From: Chris Costelloe (The Victorian Society) [chris@victoriansociety.org.uk]
Sent: 11 July 2012 18:34
To: Jane Tucker
Subject: RE: Consultation on planning application 3/2012/0558 mill adjacent to Primrose House, Primrose Rd, Clitheroe

Please can you let us have your comments on the above planning application? It is for the proposed conversion of the former mill building into an apartment, design studio and internal garden.

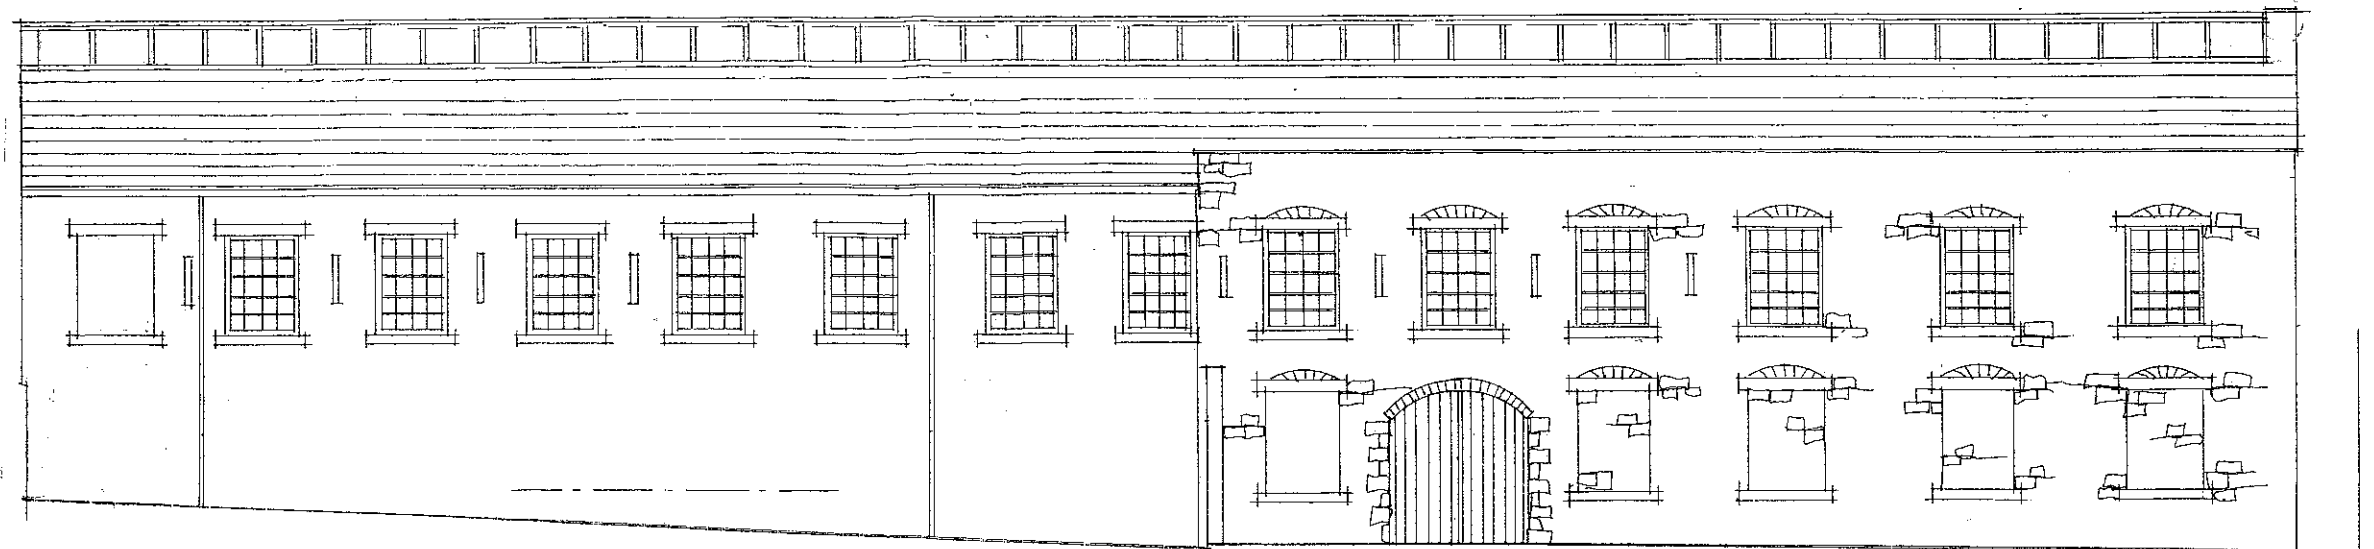
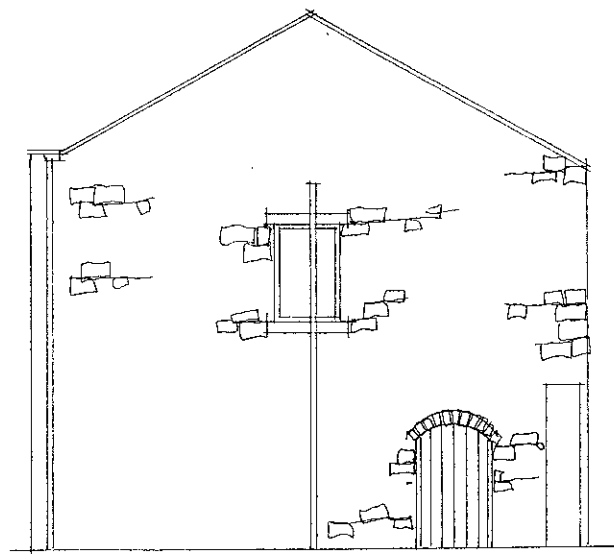
Thank you for consulting us on this. In general it seems like a reasonably sensitive proposal. However, we would prefer it if the existing small-paned windows were retained, as they are an important element of the character of the building, and if new windows maintained this effect. In particular, it should be possible for the internal garden section of the building to use the original windows, as heat retention will not be a factor in this part of the building.
